Charlie Williams
Flat 2
74 South Terrace
Littlehampton
England
BN17 5LE

Your Ref: OWPC22155
Our Ref: LU/91/19/PL 21-03-2019
Please ask for:
Andrew Wood

Change of use of parts of seafront for temporary food & drink outlets & other seaside uses together with associated temporary/portable structures & equipment for use by businesses associated with those outlets.

Various sites along Littlehampton Promenade Littlehampton

SITE LOCATION PLAN AND
BLOCK PLAN - SITE C&D

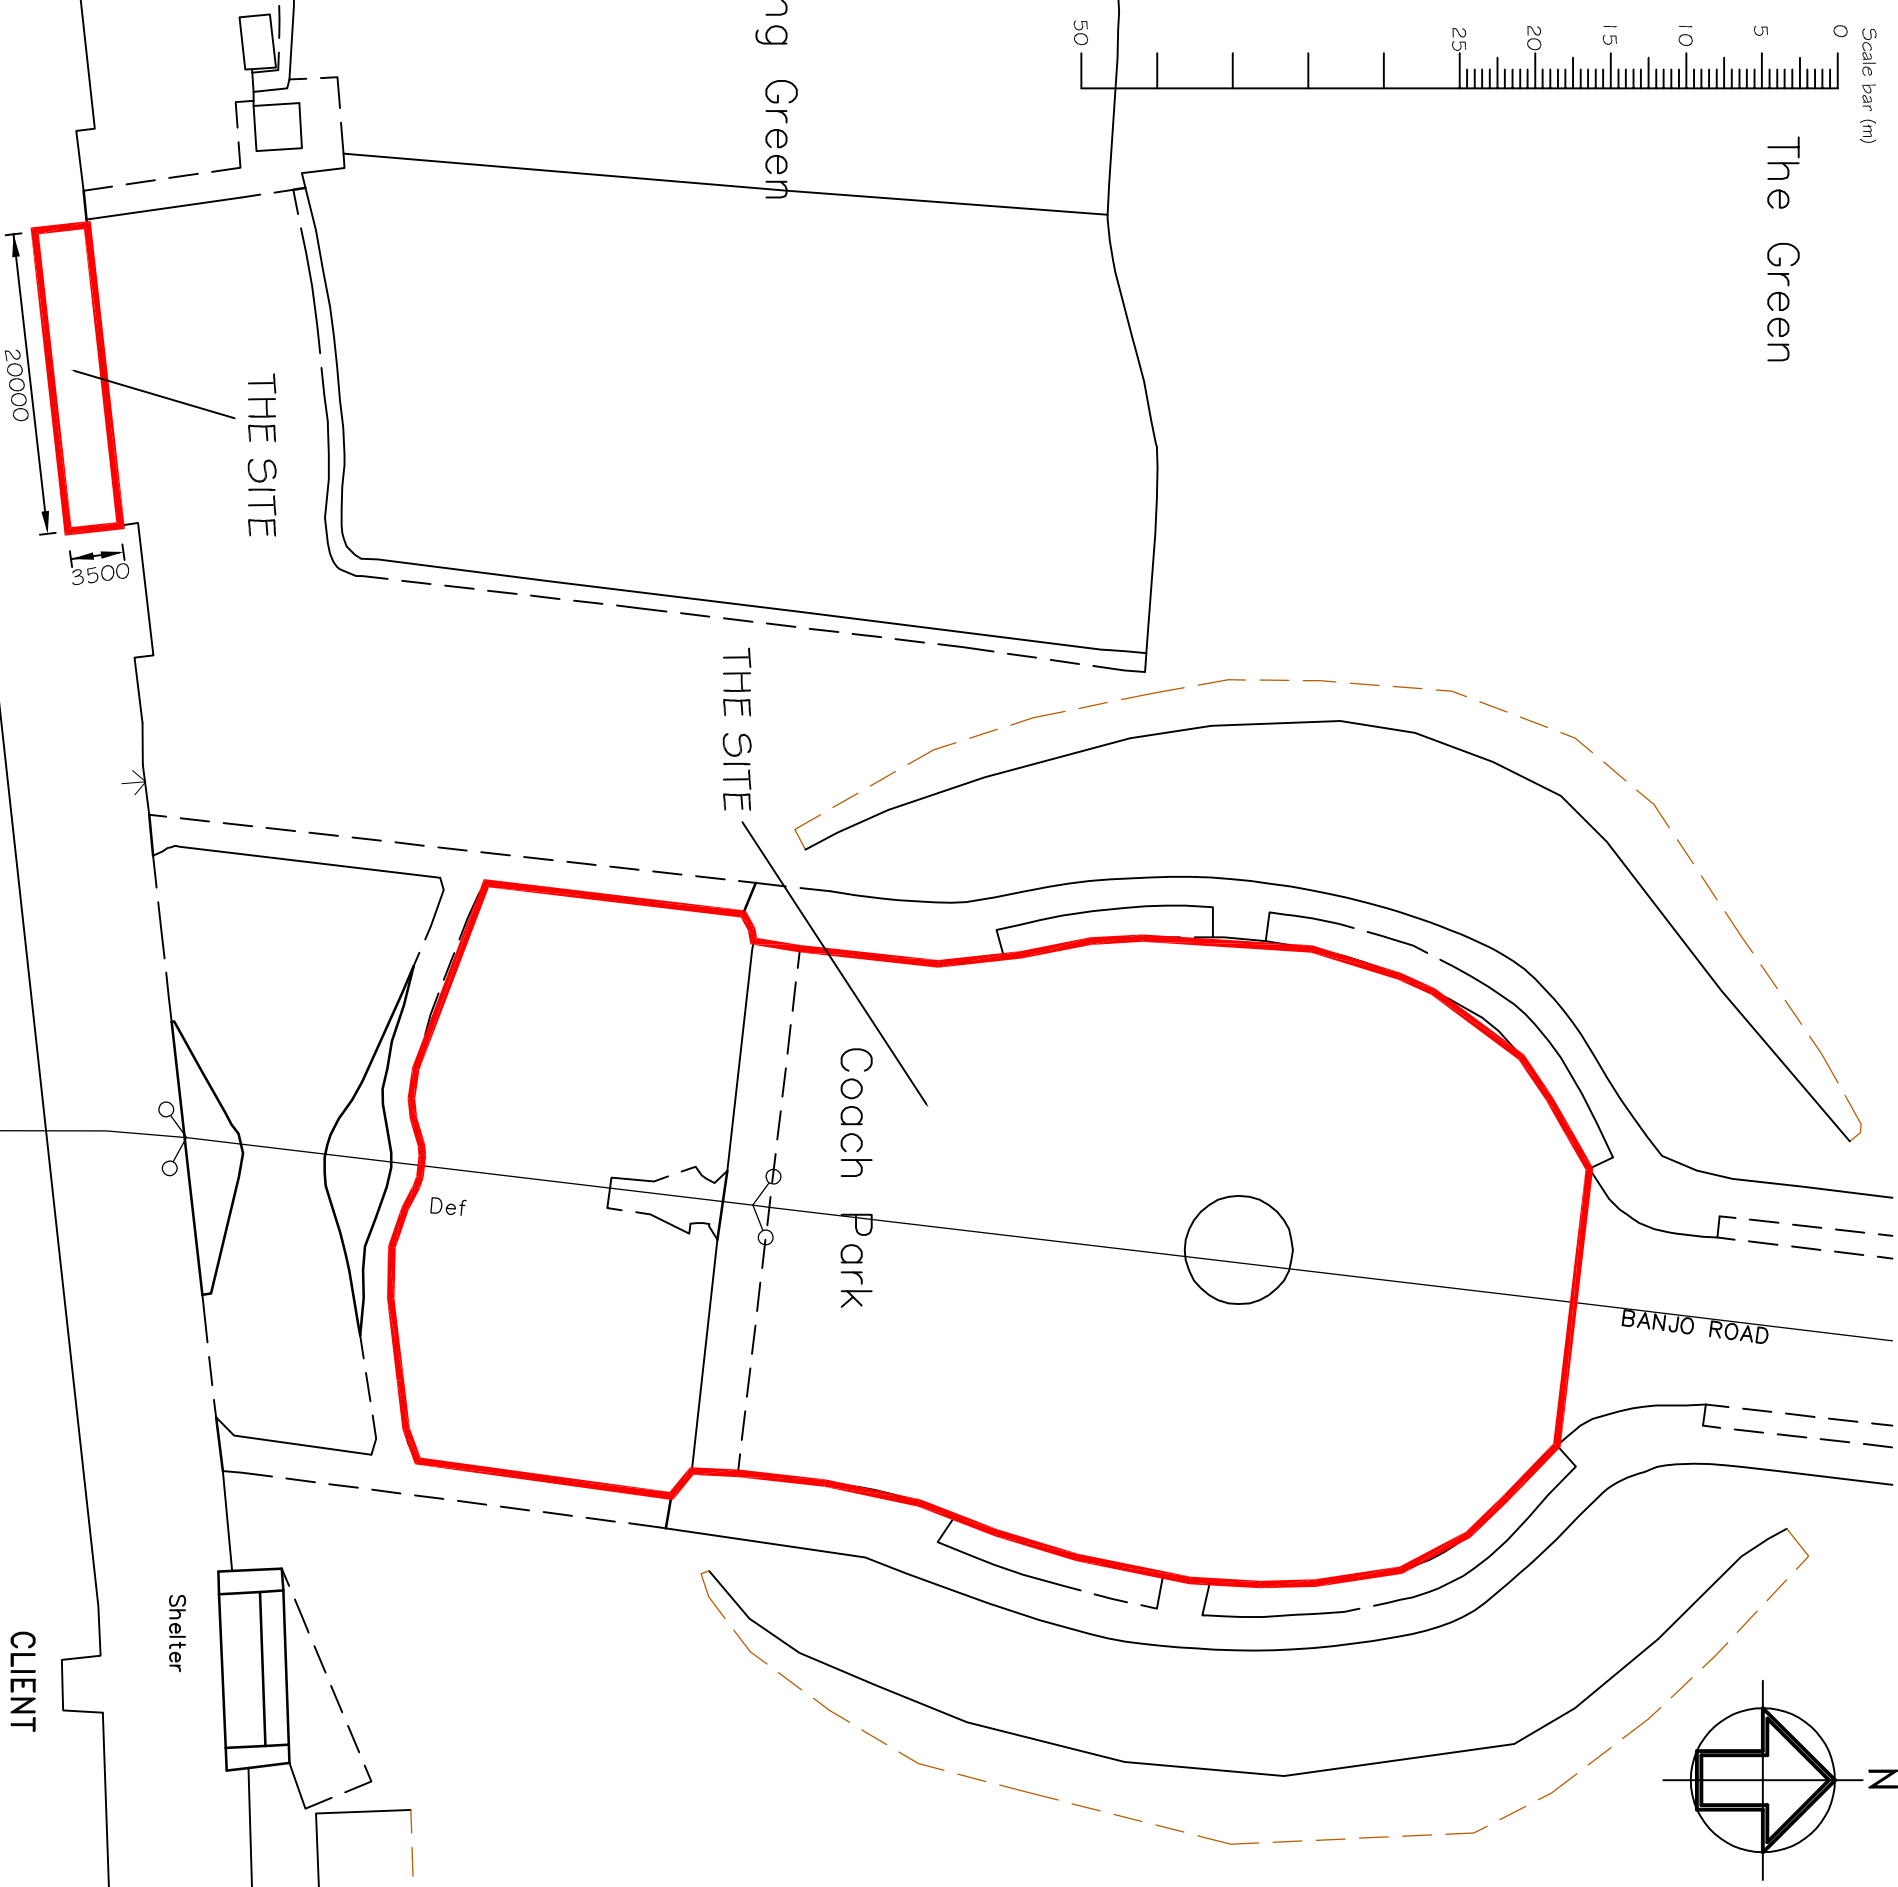
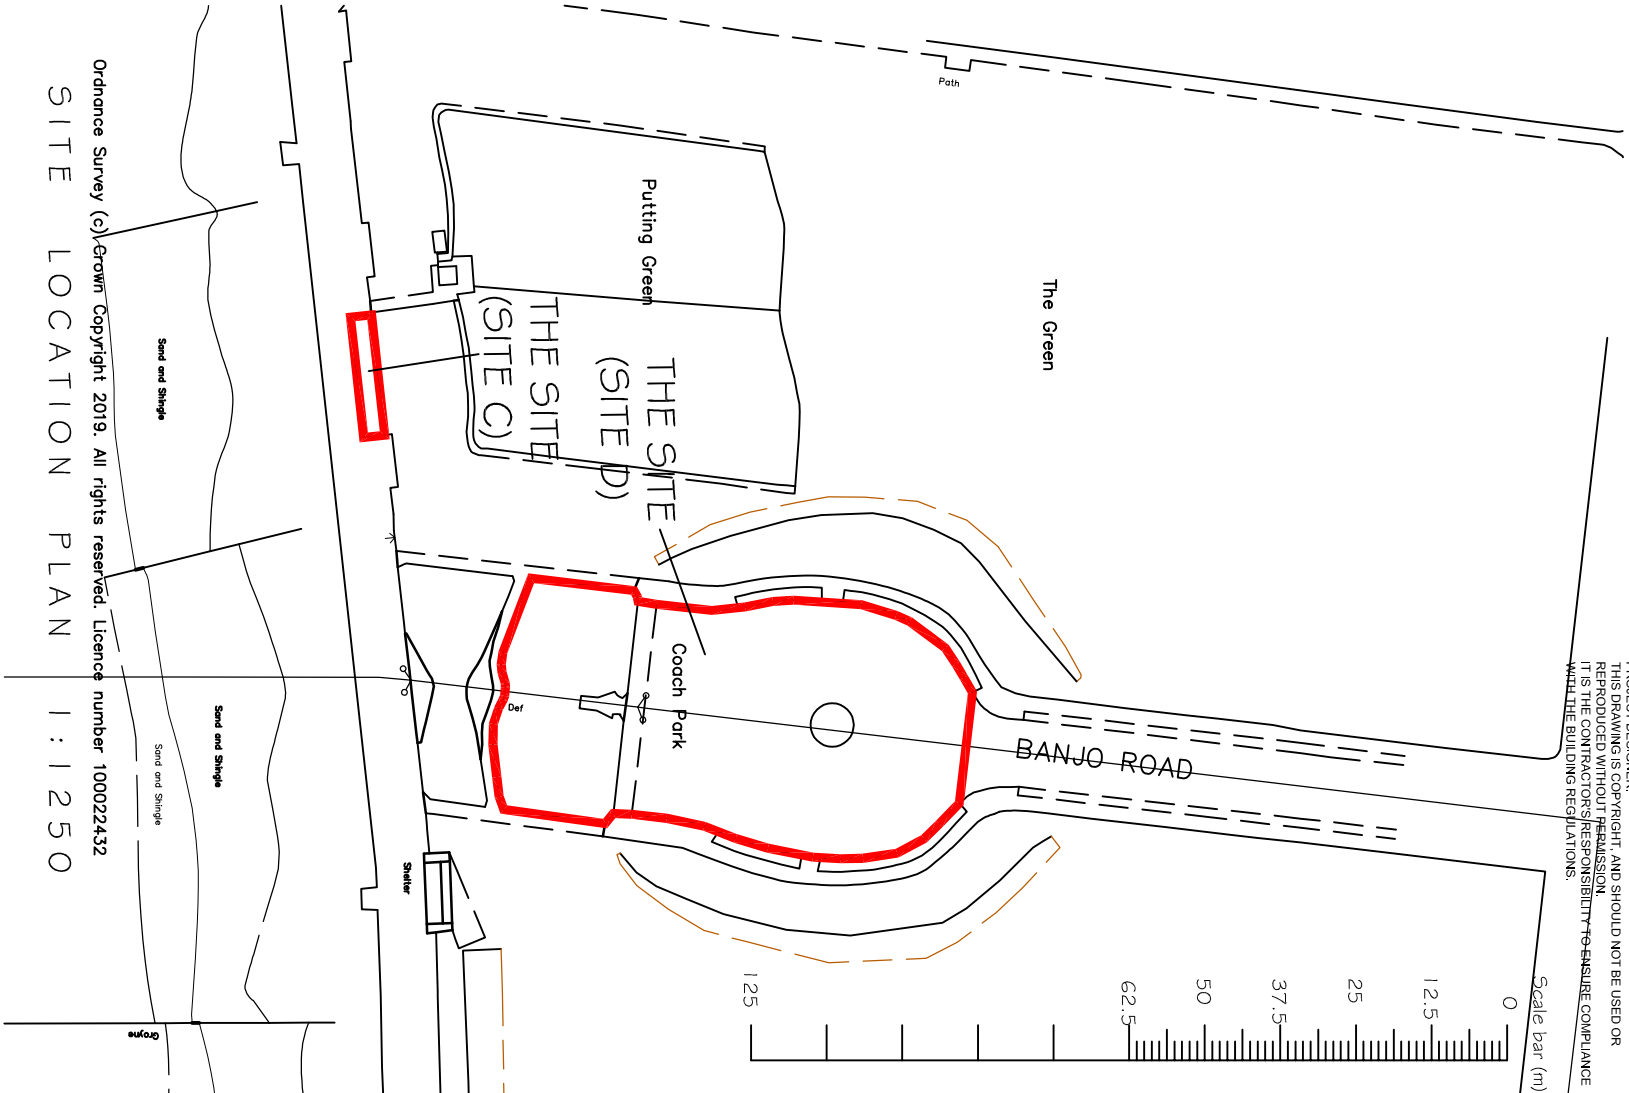
Site C Observations - That this will have a major effect on the sustainability of the permanent purpose-built kiosk business's already providing, that which is being proposed, and trading for long periods not just at the busy times which is what it relies on to survive. It is over development.

Site C - Objections - The site is too narrow for this use and will encroach into the promenade and create a danger to people enjoying the prom, walking, bike riding or on the road train, especially in busy times when these mobiles would be operating with no queue area accounted for. This will make the area dangerous for promenade users. It is also out of keeping with the character of the prom.

Site D - Objections - To the loss of the coach park. Coaches will try to park anywhere they can and cause great hold ups and a nuisance to the residents. Loss of trade from the coaches - One coach can bring up to 60 people in one vehicle, environmentally better than individual cars.
